Ribble Valley Borough Council
Housing & Development Control

Your ref: 3/2023/0190
Our ref: D3.2023.0190
Date: 19th May 2023

Application no: **3/2023/0190**

Address: **Waddington Arms Clitheroe Road Waddington BB7 3HP and 58 West View Clitheroe Road Waddington BB7 3HP**

1 Vehicle access/Parking Plan
1:125

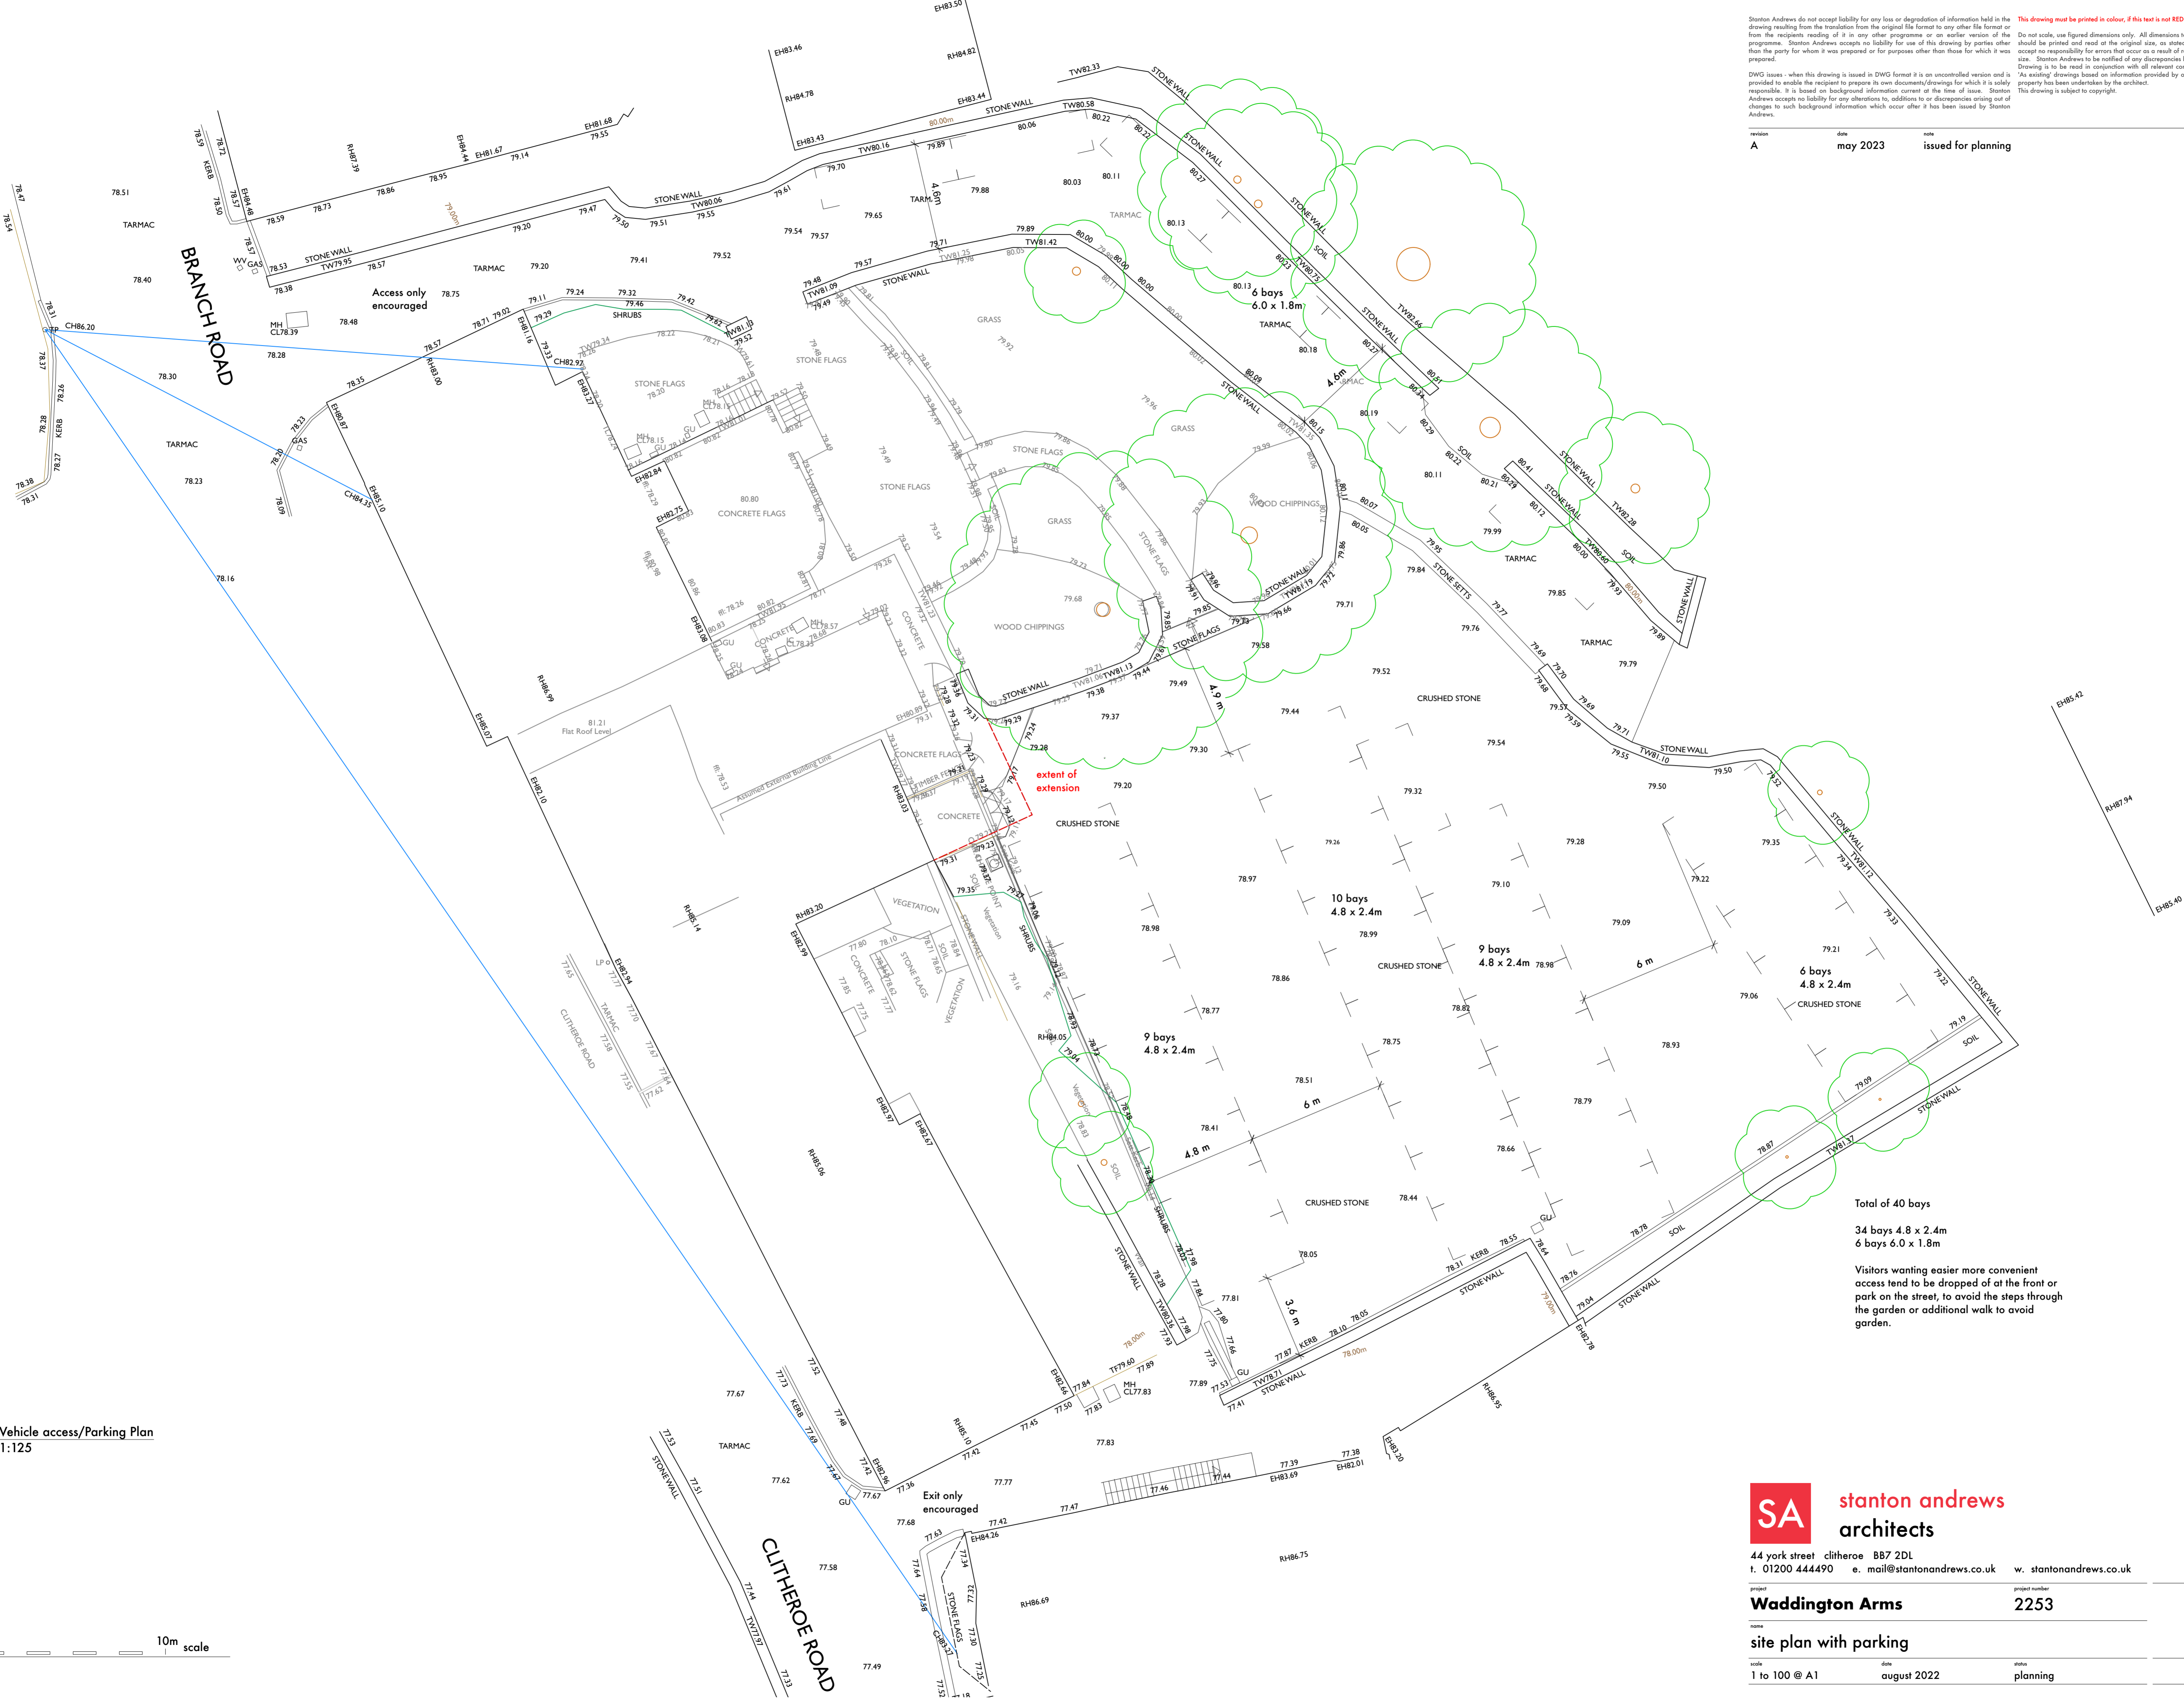
The LHA have reviewed Stanton Andrews drawing number PL.00 Rev A titled "Site Plan with Parking" and are aware that the site has access to two accesses. One of the accesses is located off Branch Road while the other is located off Clitheroe Road, a B classified road subject to a 30mph speed limit.

The LHA are aware that the Public House tries to encourage that both accesses are utilised in, an "in, out" formation. With the access located off Branch Road being the "in" access while the access located off Clitheroe Road being the "out."

The LHA have reviewed the current access arrangements and have no comments to make given that they are existing and have been established for numerous years.

The LHA have reviewed Stanton Andrews drawing number PL.00 Rev A titled "Site Plan with Parking" and are aware that the main car park can provide 34 car parking spaces should the area become formalised and 6 informal parallel bays are provided around the access track into the car park to serve the proposal.

However, to ensure that there is adequate spare capacity at the site to cope with the greater demand for car parking spaces following the proposal, with there being 18 additional covers following the extension to the dining area and 5 additional Bed and Breakfast bedrooms, the LHA will request that a parking survey is conducted.

The parking survey should be conducted during peak times, with the LHA requesting the survey to be conducted on a Friday and Saturday evening between 18:00 to 22:00 when it is considered to be the busiest times for the Public House.

The LHA remind the Agent that a Public House is required to provide 1 space per 8 square meters of internal floor area, while a Bed and Breakfast establishment is required to provide one car parking space per bedroom to comply with the LHAs parking guidance as defined in the Joint Lancashire Structure Plan. Therefore, the extension to the Public House should provide an additional 17 car parking spaces following the proposal.

The LHA require a parking survey to be conducted in the car park for the Public House on a Friday and Saturday evening to assess whether the car park has adequate spare capacity to cope with the greater demand for car parking spaces following the proposal. The LHA remind the Agent that an additional 17 car parking spaces should be provided for the proposal to comply with the LHAs guidance.
